From: Sharon Robinson [REDACTED]
Sent: 29 September 2017 14:05
To: Mark Jones; Planning
Subject: RE: Planning Application FP/193/17/HH

Proposed North Elevation

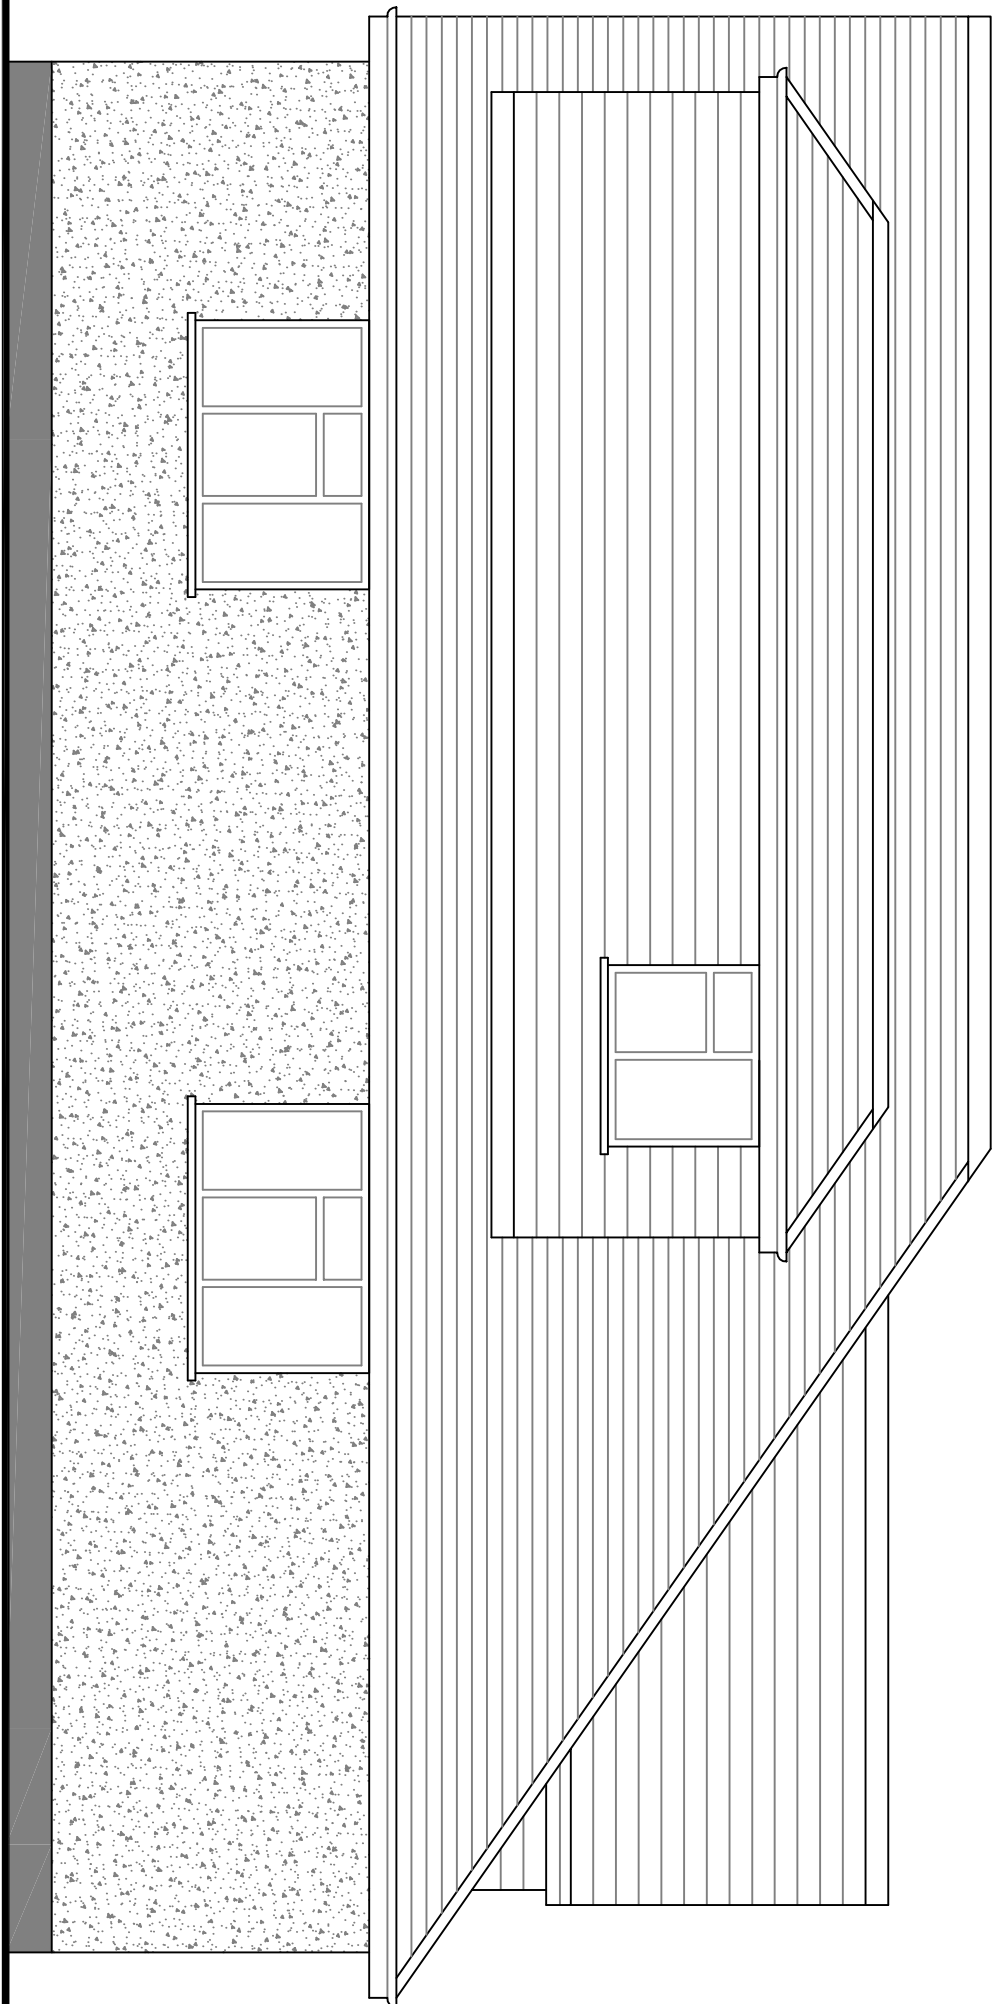
I am uncertain about your explanation that at this early stage in the process it would not be feasible for the applicant to provide such measurements, however I would just like it put on record that the cill height to both of the dormers on the north elevation is material to this application and any objections, therefore we would need these measurements provided as they cannot be scaled from the drawings that have been published on the planning portal of your web site

With regard to the cill height, it is the interior measurement that we need please, externally this doesn't seem to be high enough and I would ask that this point be clarified so that I am able to raise this within my comments. I would ask that you request that the applicant provides the scaled height of the internal cill on the north dormer. I am aware that it would need to be 1.8m above the floor to prevent overlooking, alternatively it may need to be designed more as a 'slit' which design wise would fit in much more with the houses on the estate.

The submitted plans are to scale and as such the height of the dormers and their cill can be obtained from the plans, the thick black line would be ground level. At present my initial calculation is exterior cill height is approximately 3.8m high. However, this will be assessed further when detailed consideration of the application is undertaken at the end of the consultation period.
